EAST PRESTON PARISH COUNCIL

Re: Planning Application EP/158/19/HH – The Breakers, 29 Tamarisk Way, East Preston, BN16 2TE

Elevations as Proposed

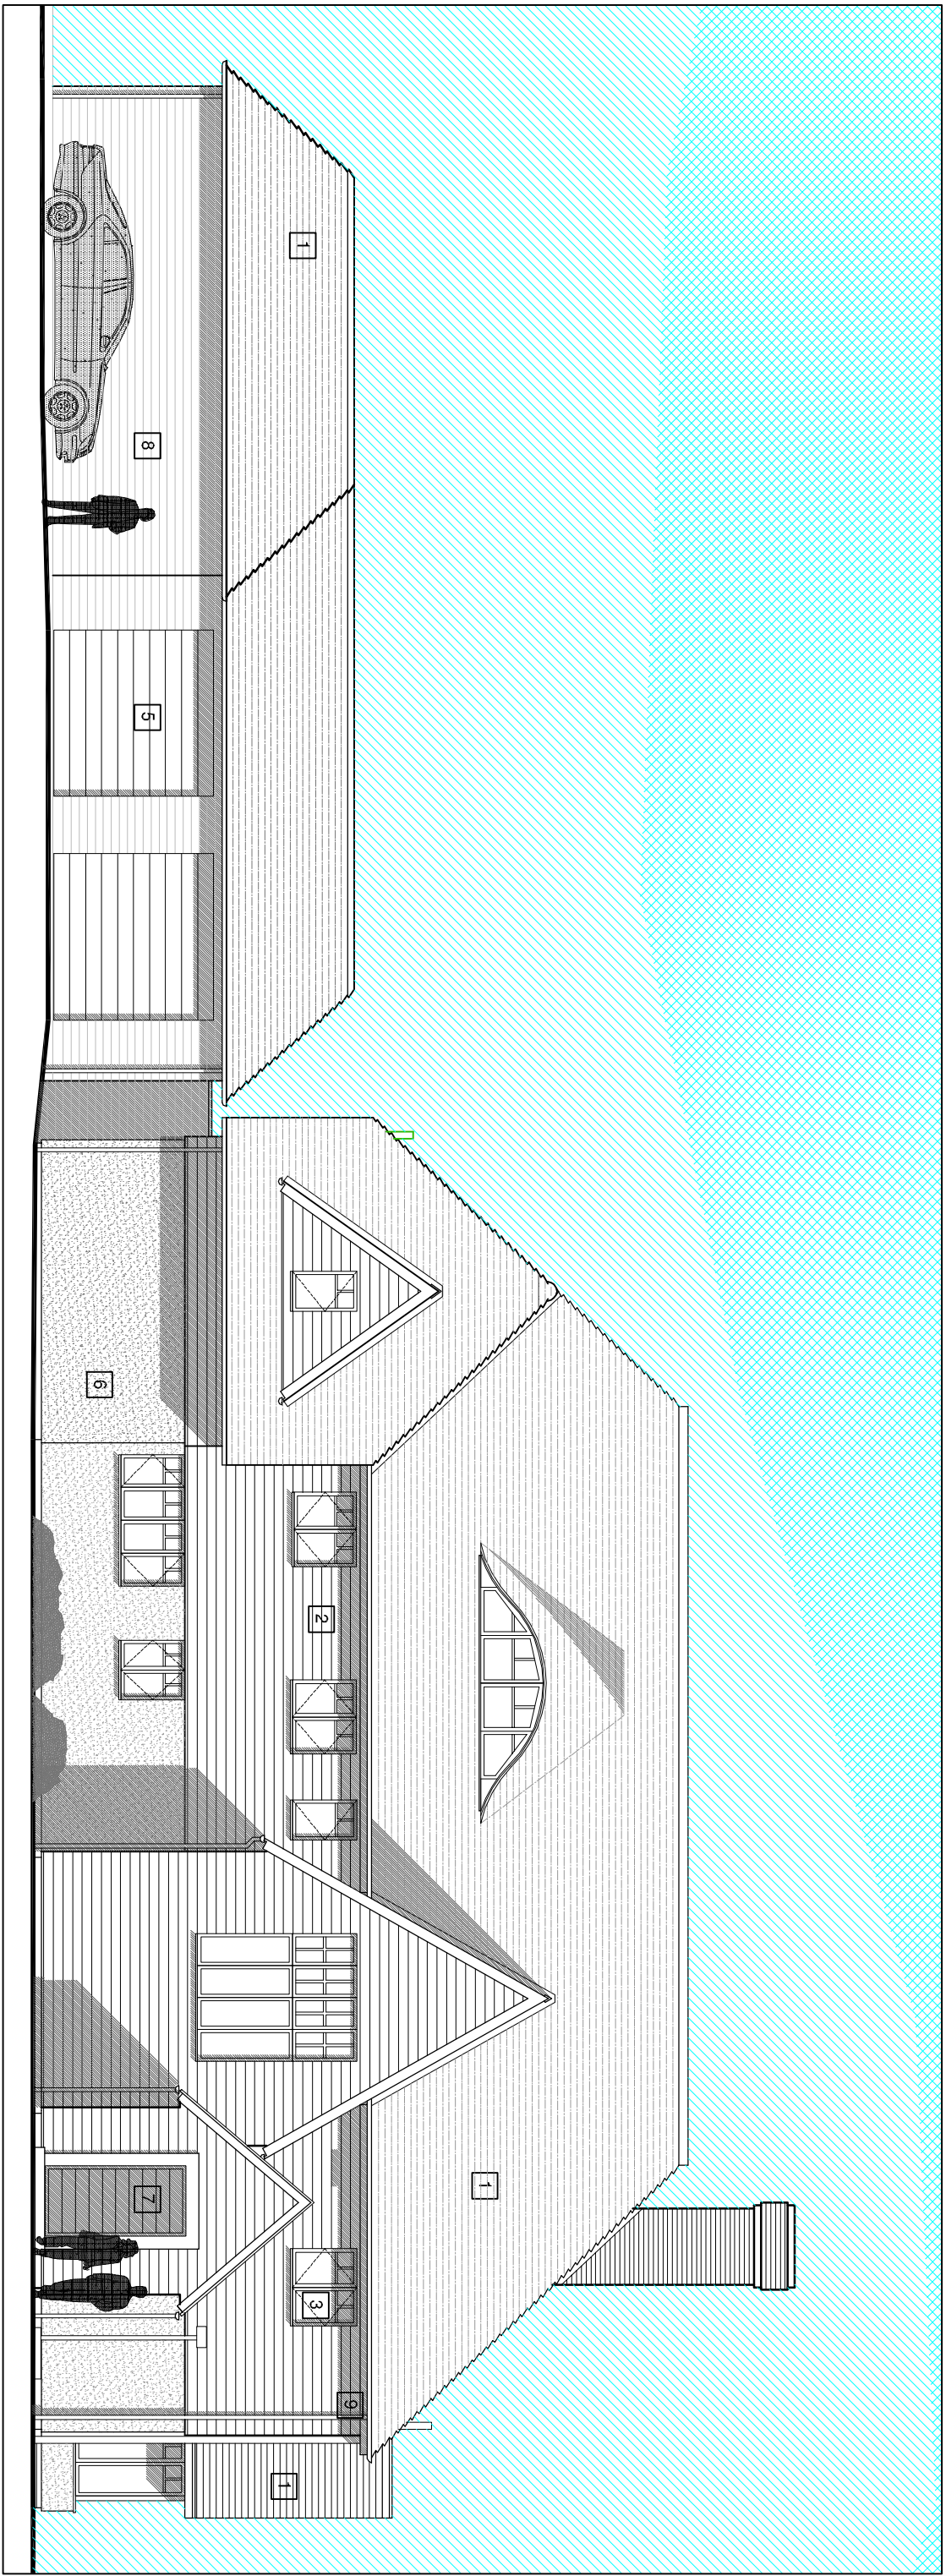
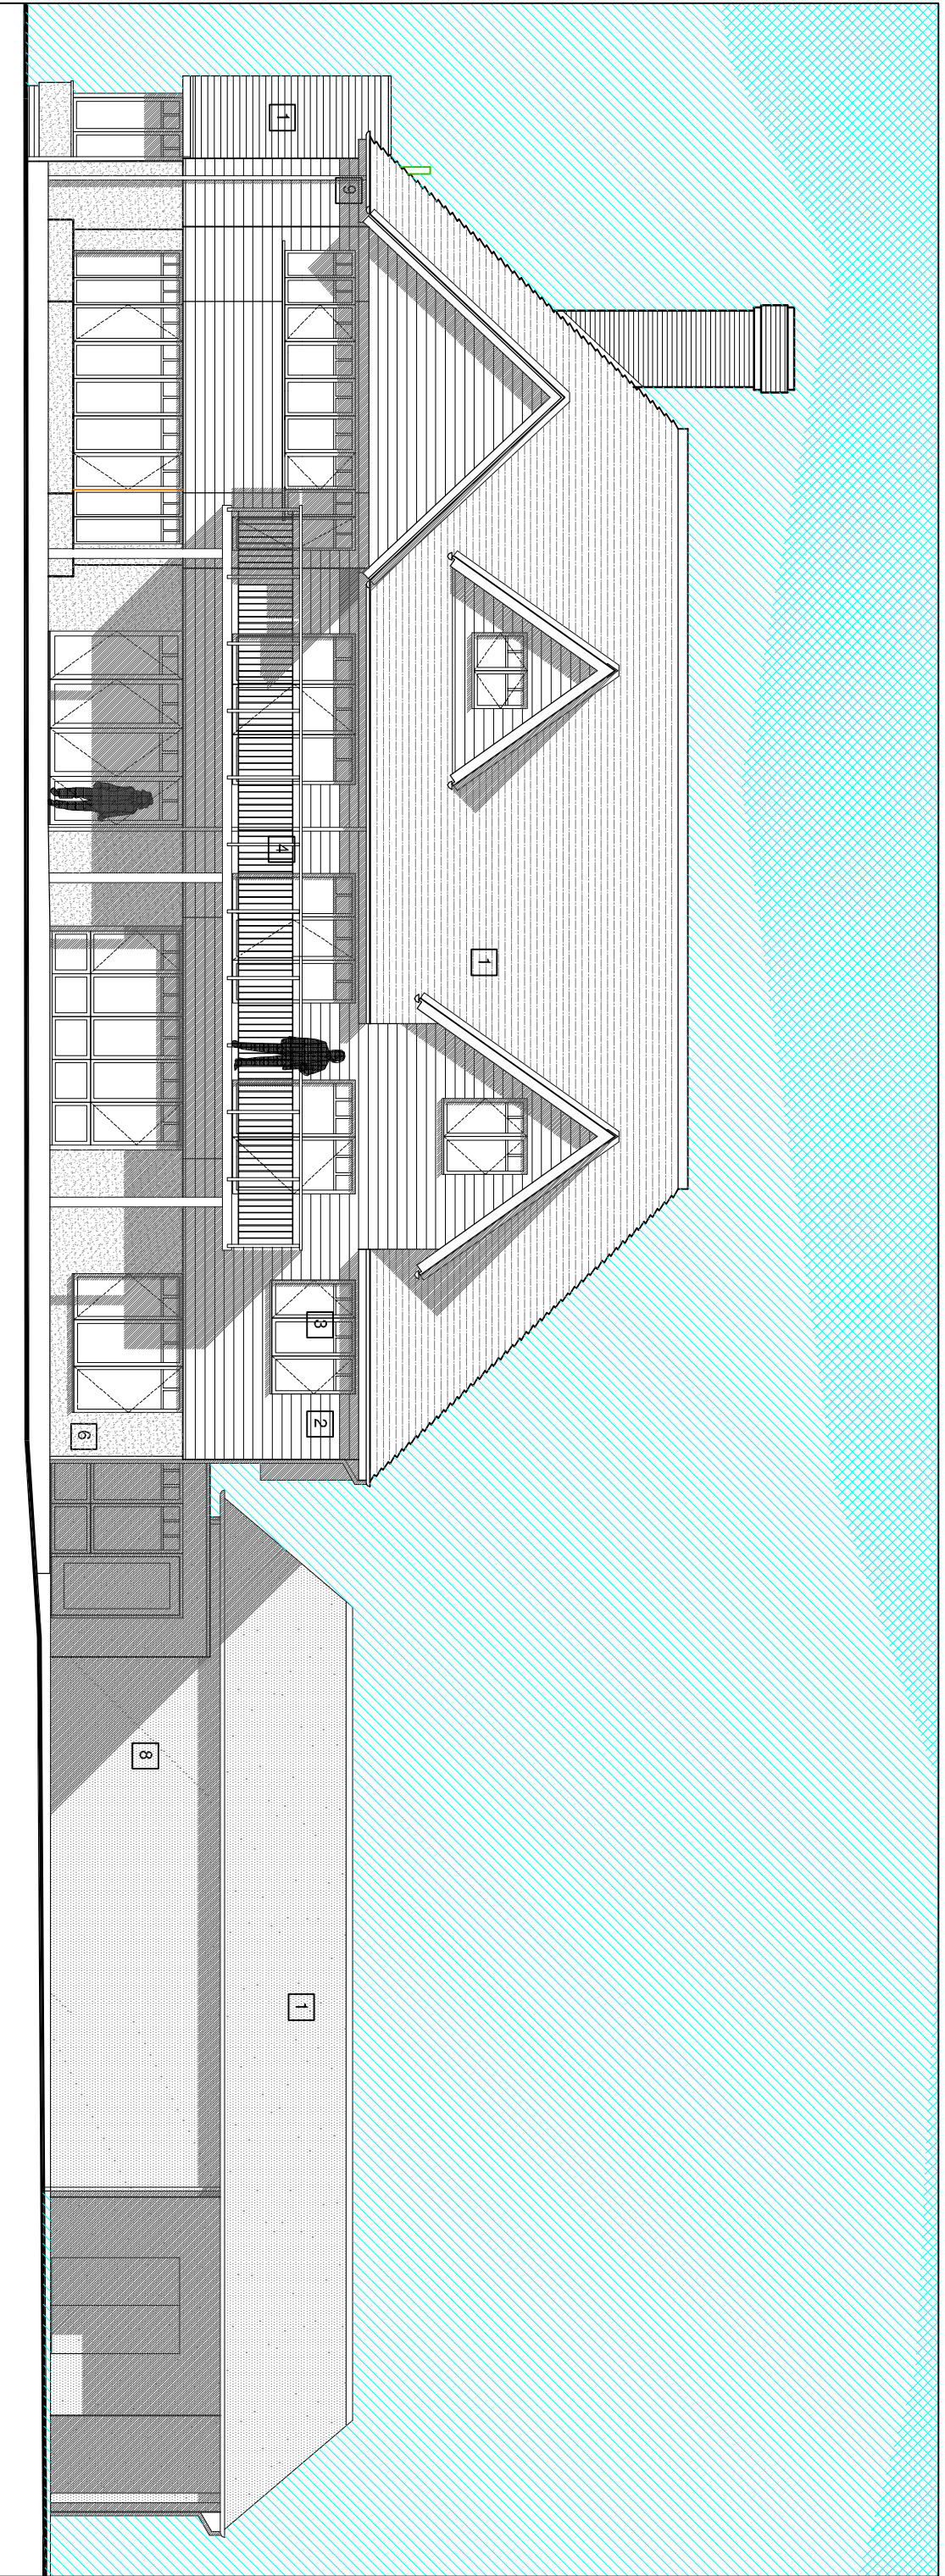
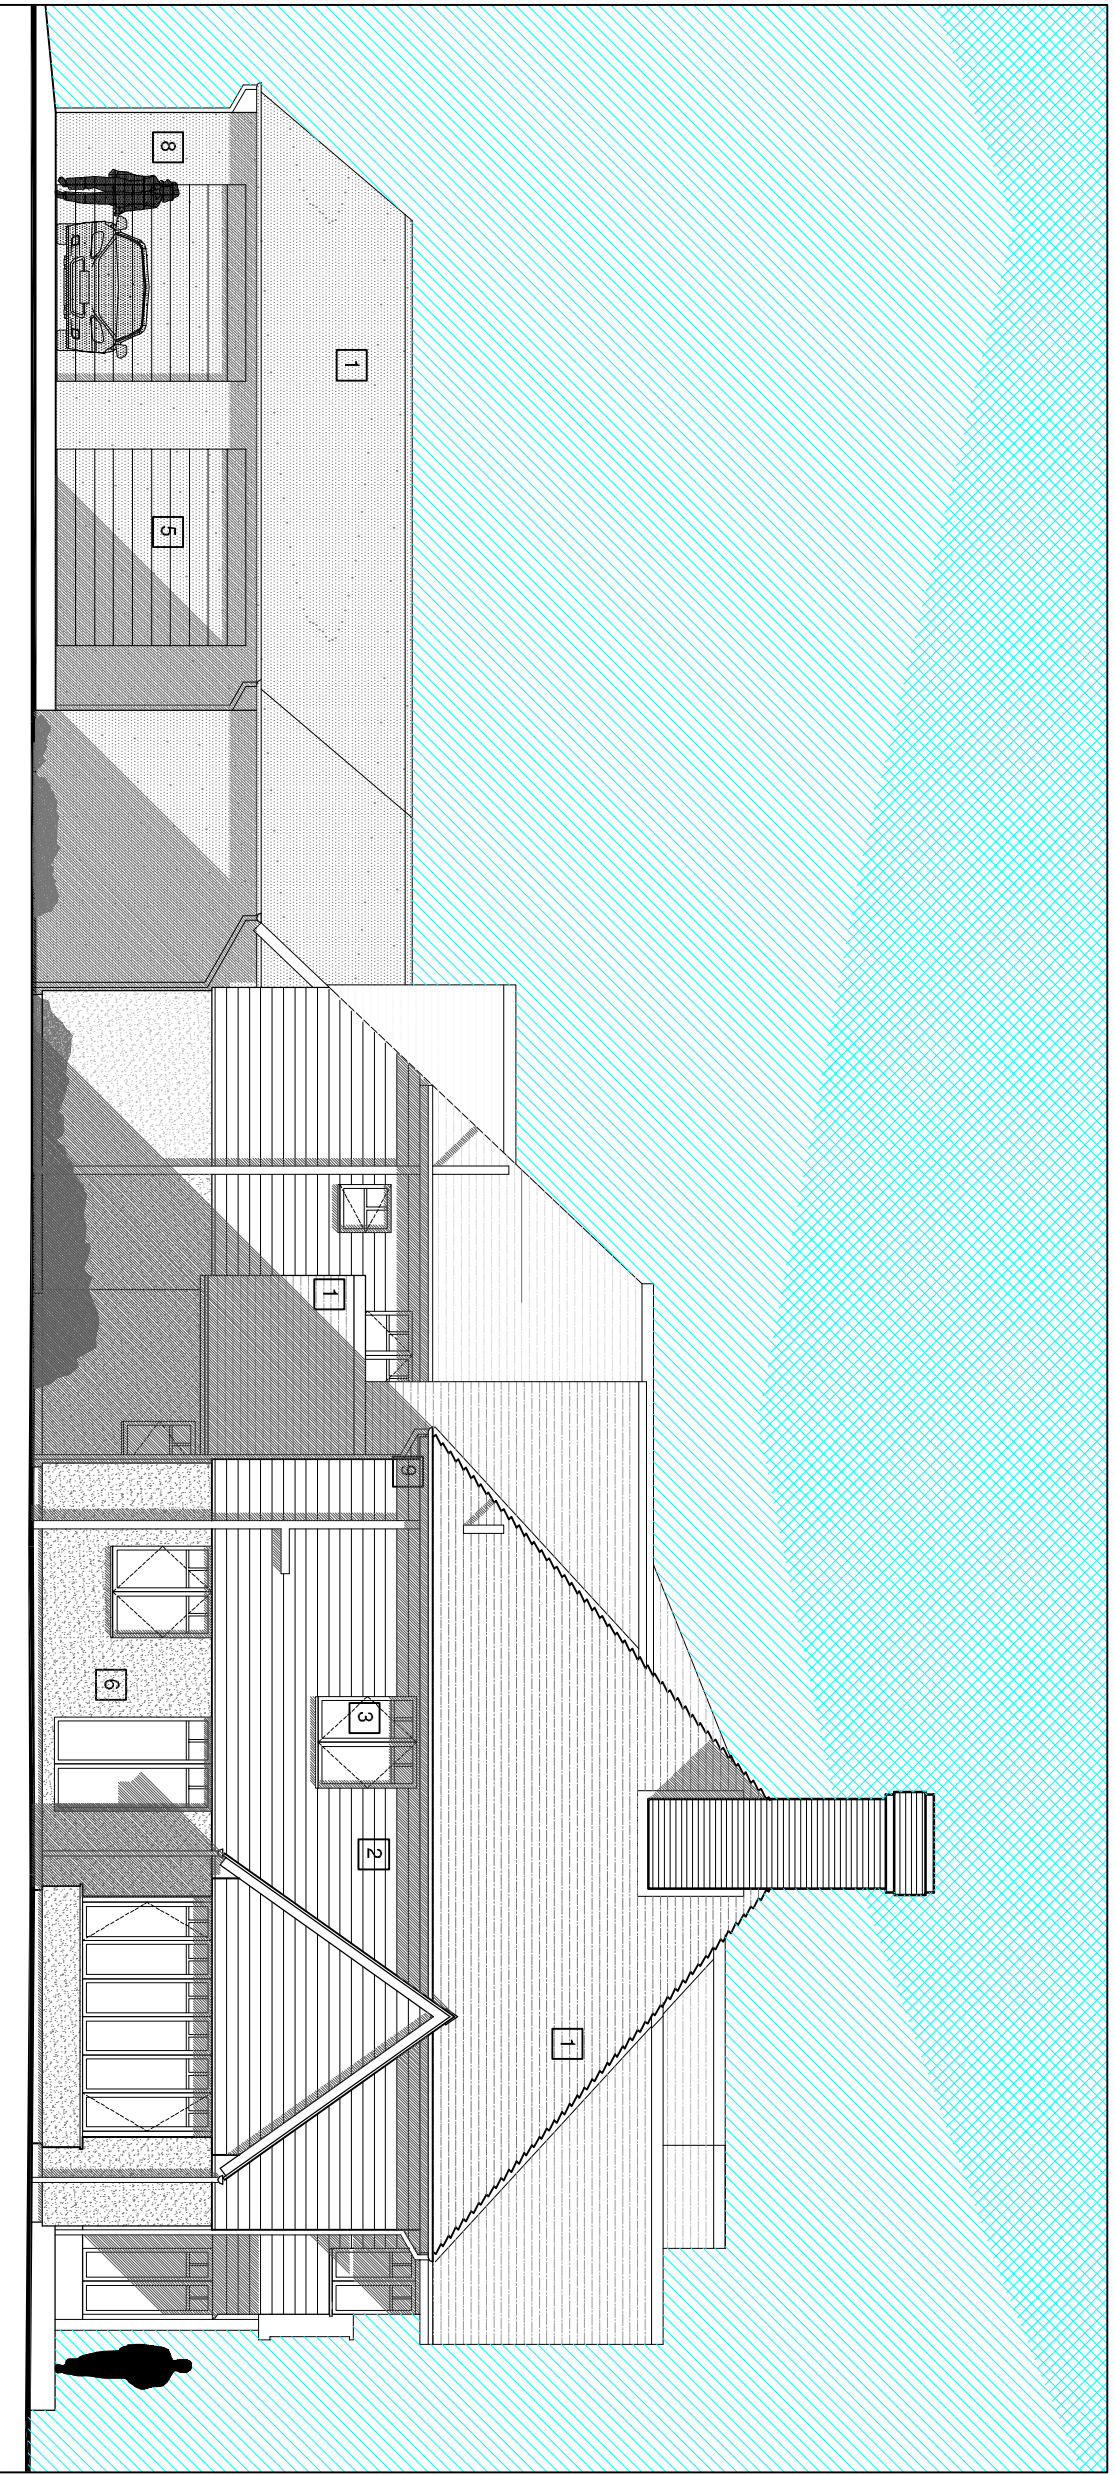
One of the headlines of Policy 2: Design in Character Area One is "Development proposals [...] will [...] protect the view from the beach." The overwhelming changes being proposed for the southern elevation clearly do not meet that headline.

It may be an anomaly with the drawings but the proposed roof over the eyebrow window on the northern elevation appears NOT to set the apex of the roof above the apex of the eyebrow. This would likely result in a very out-of-kilter feel to that window/roof combination. The National Planning Policy Framework allows Local Planning Authorities to refuse Planning Permission on the grounds of poor design.
